STATE OF NORTH CAROLINA
DEPARTMENT OF TRANSPORTATION

April 1, 2015

SUBJECT: **Request for Modification of the Section 404 Individual Permit, Section 401 Water Quality Certification, and Neuse River Riparian Buffer Authorization** for the proposed East End Connector from NC 147 (Durham Freeway/Buck Dean Expressway) to north of NC 98 (Holloway Street) in Durham, Durham County, North Carolina, Division 5. Federal Aid Project No. NHF-76-1(2), TIP No. U-0071.

In addition to this cover letter, please find enclosed the revised Division of Mitigation Services (DMS) (formerly EEP) Acceptance Letter, revised Wetland Permit Drawing Sheet Nos. 20, 21, 36, 37, 60, 61, 74, 75, 90, and 91 of 91 and Buffer Permit Drawing Sheet Nos. 5 through 7 and 18 of 18.

Permit Drawing
Sheet 74 of 91

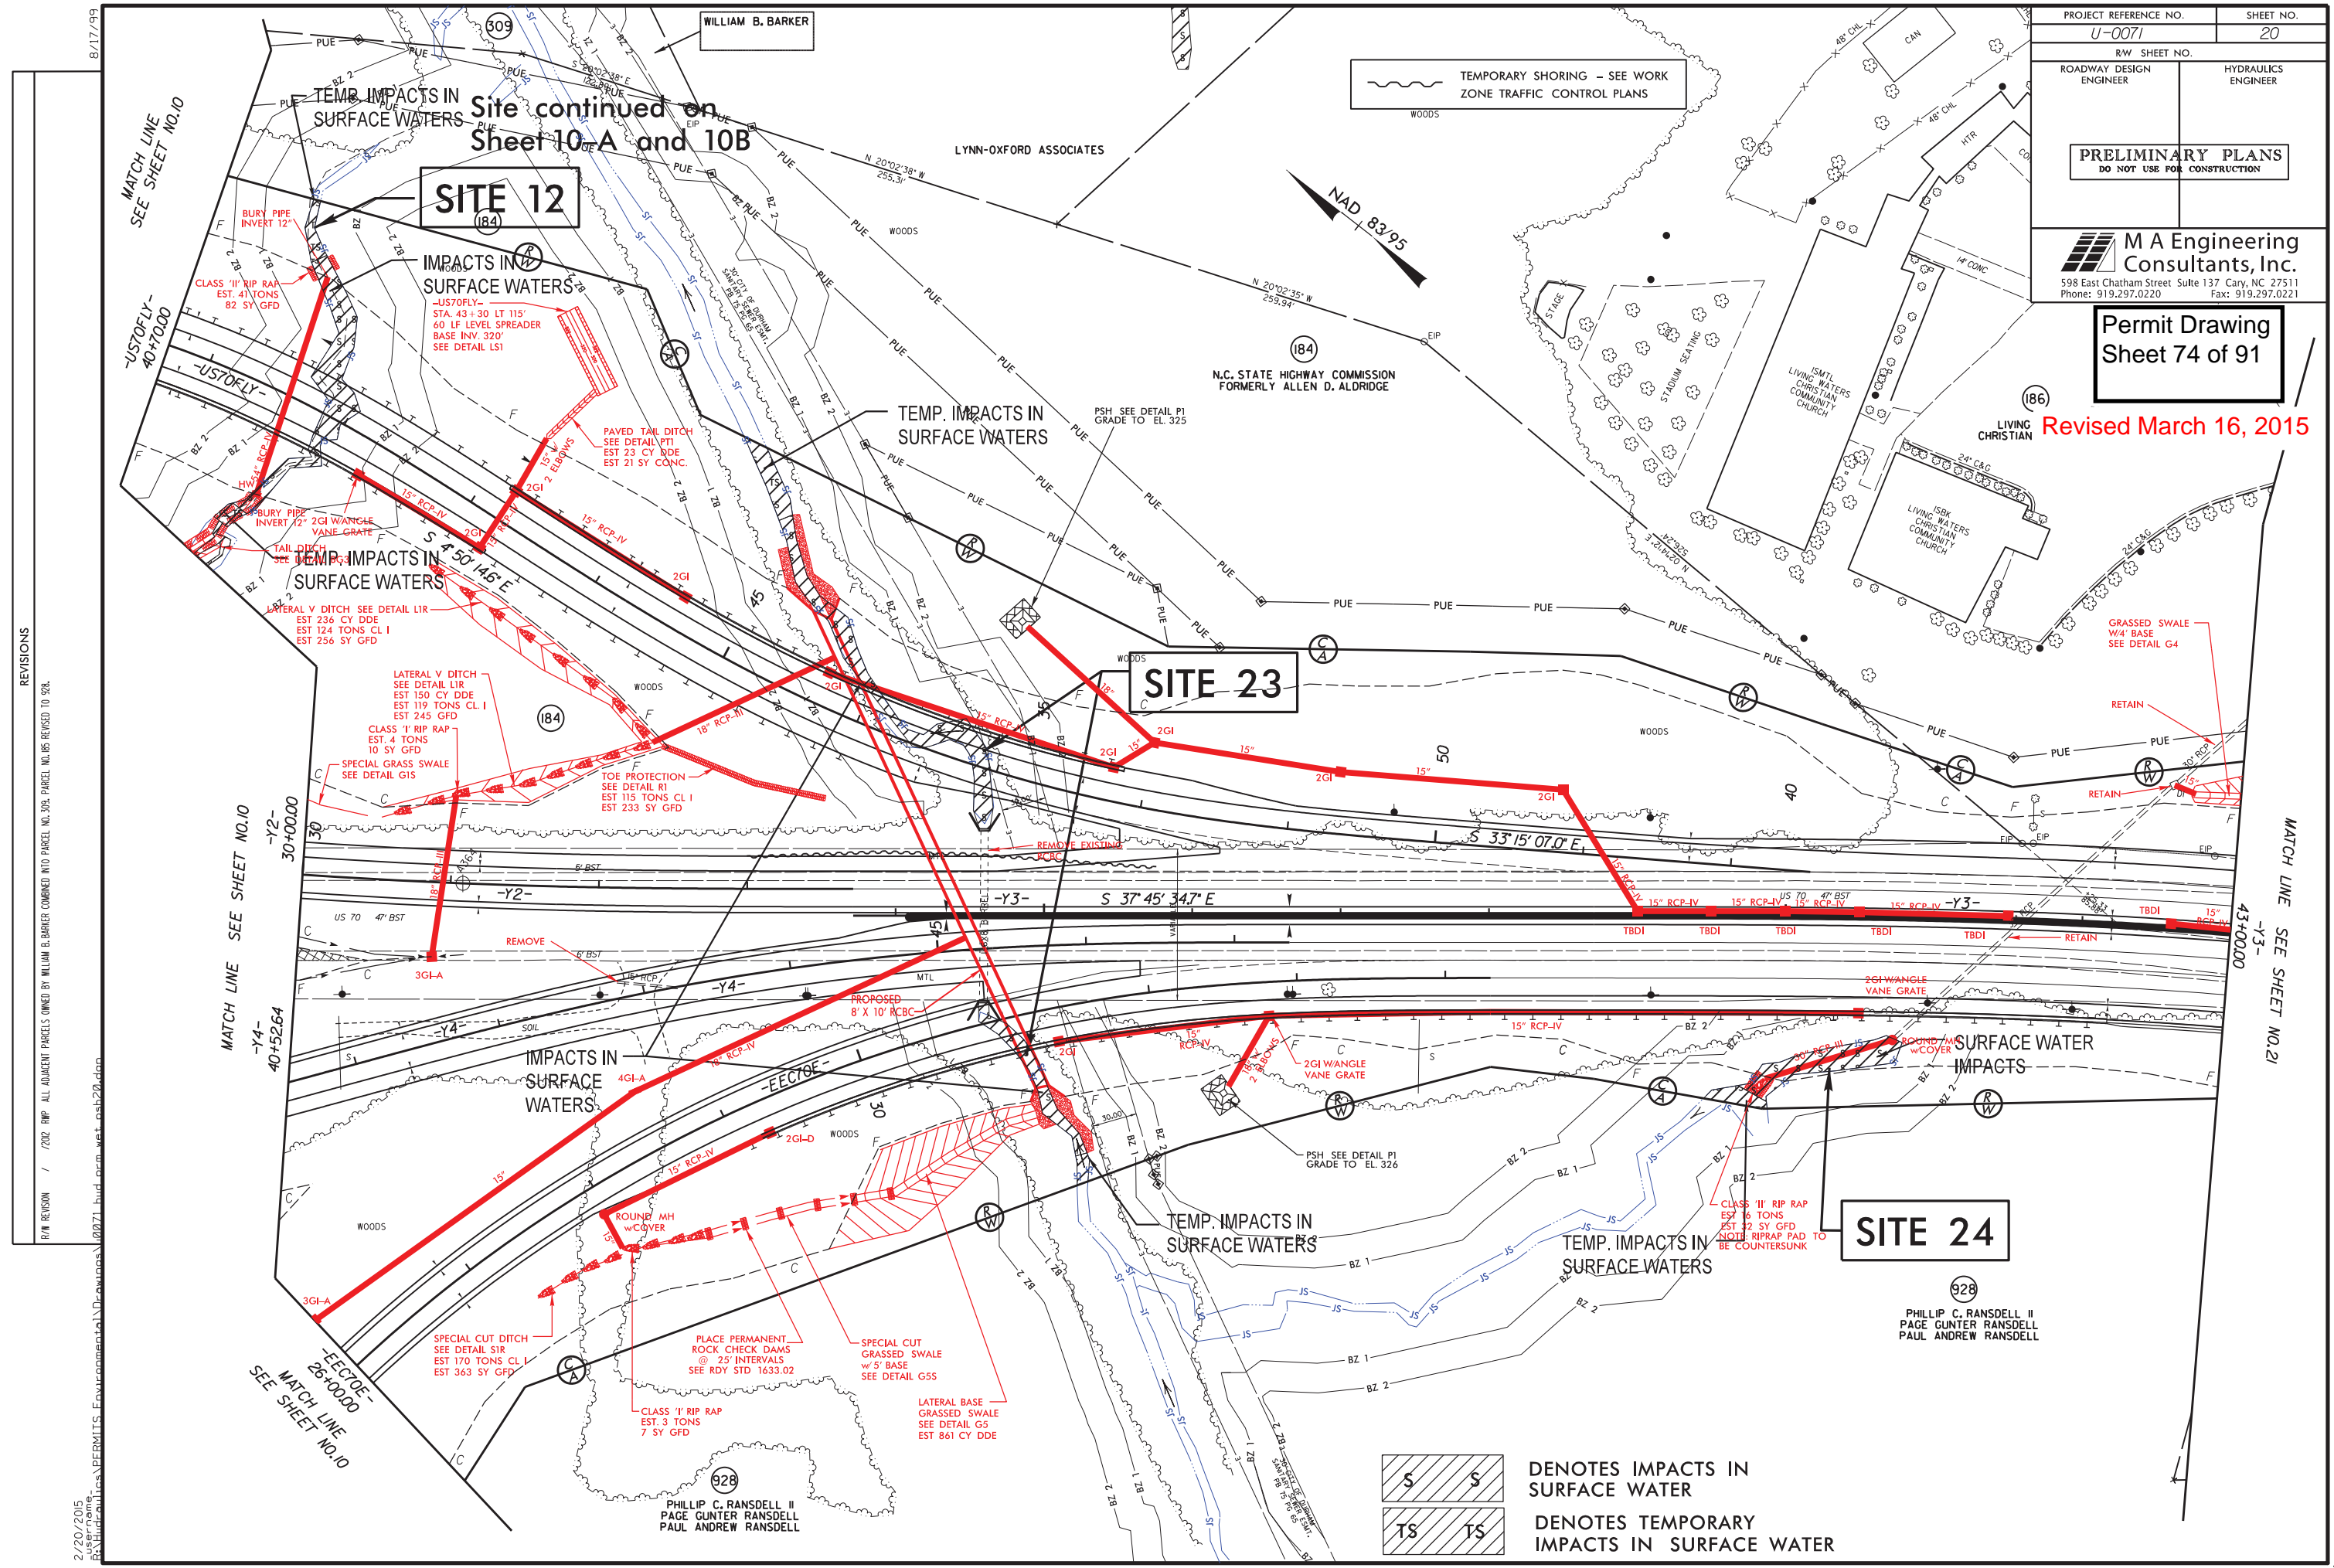
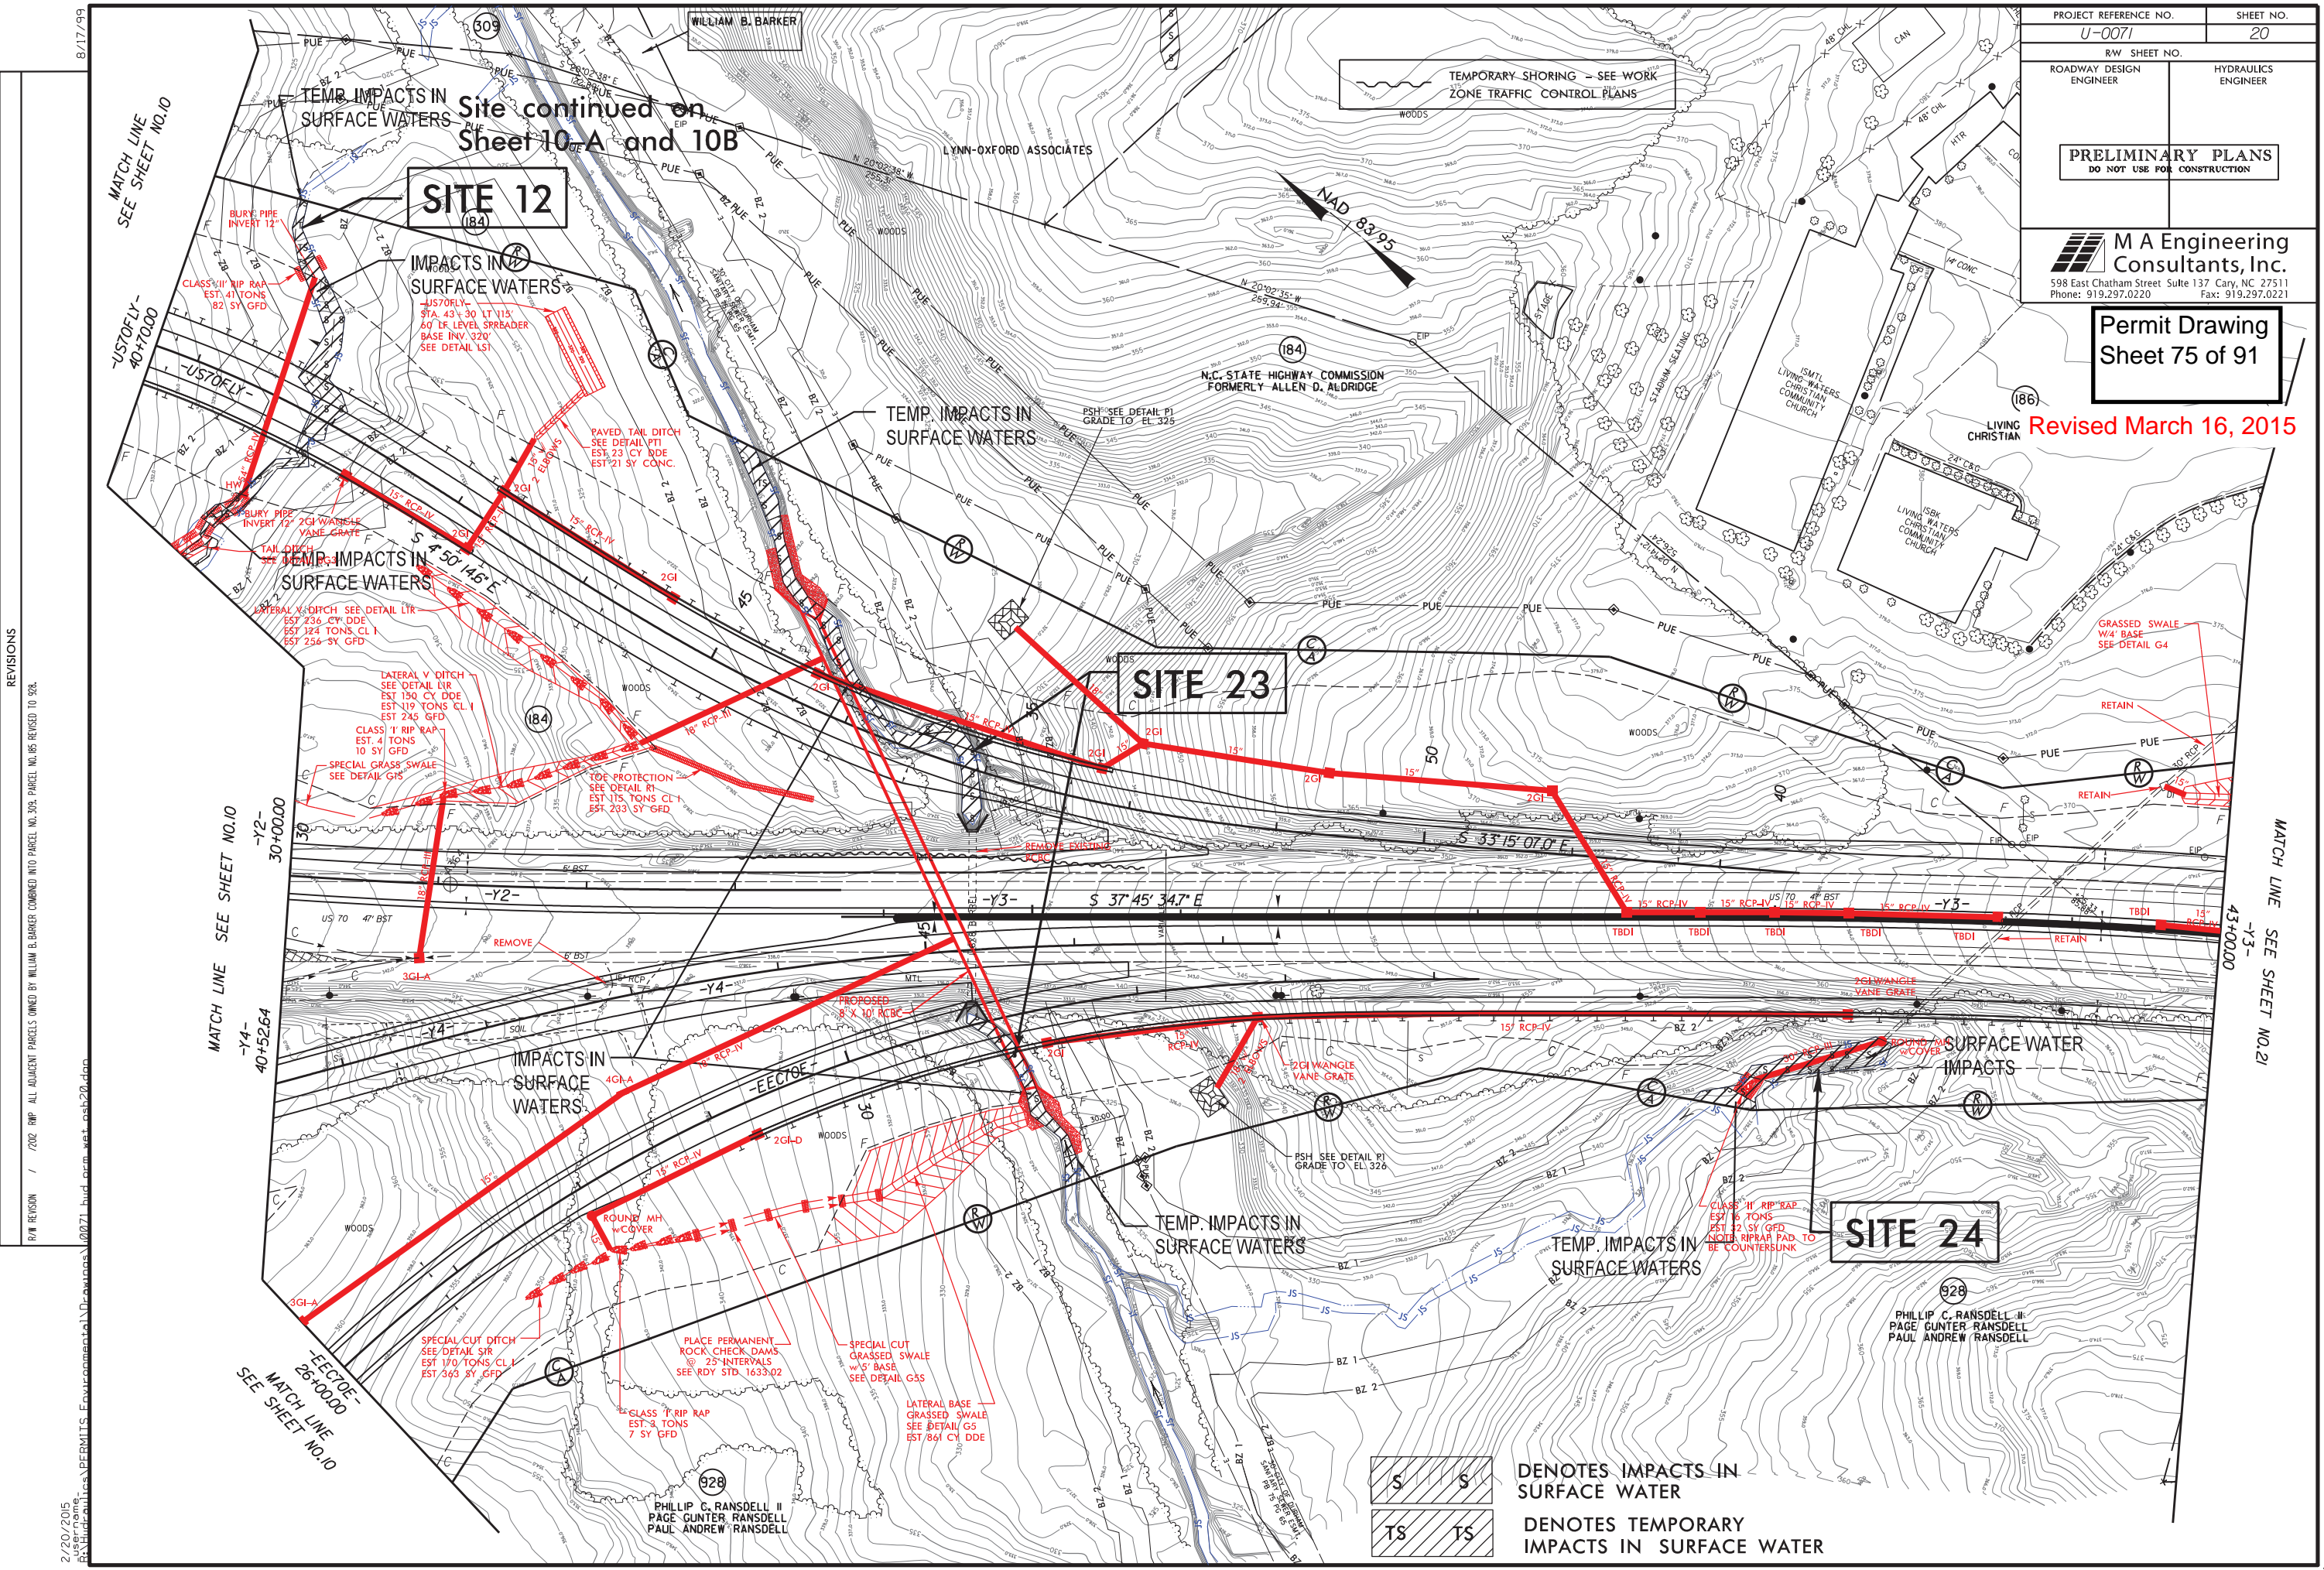
- Sites 17 and 23: A review of the culvert construction sequence indicates that the tie-in points of the temporary diversion channel at the culvert inlet and culvert outlet are located outside of the permitted bank stabilization impact footprint. A review of the stream banks at this location indicates a presence of Triassic rock. Backfilling of the tie-in points of the temporary diversion channel with native soil material will not allow for establishment of suitable streambank vegetation. Accordingly, the revision extends rip rap on the stream banks to fully cover the limits of the tie-in points of the temporary diversion channel. At Site 17, there is a reduction in temporary stream impacts of 11 linear ft. and an increase in bank stabilization of 24 linear ft. At Site 23, there is a reduction in temporary stream impacts of 48 linear ft. and an increase in bank stabilization of 48 linear ft.
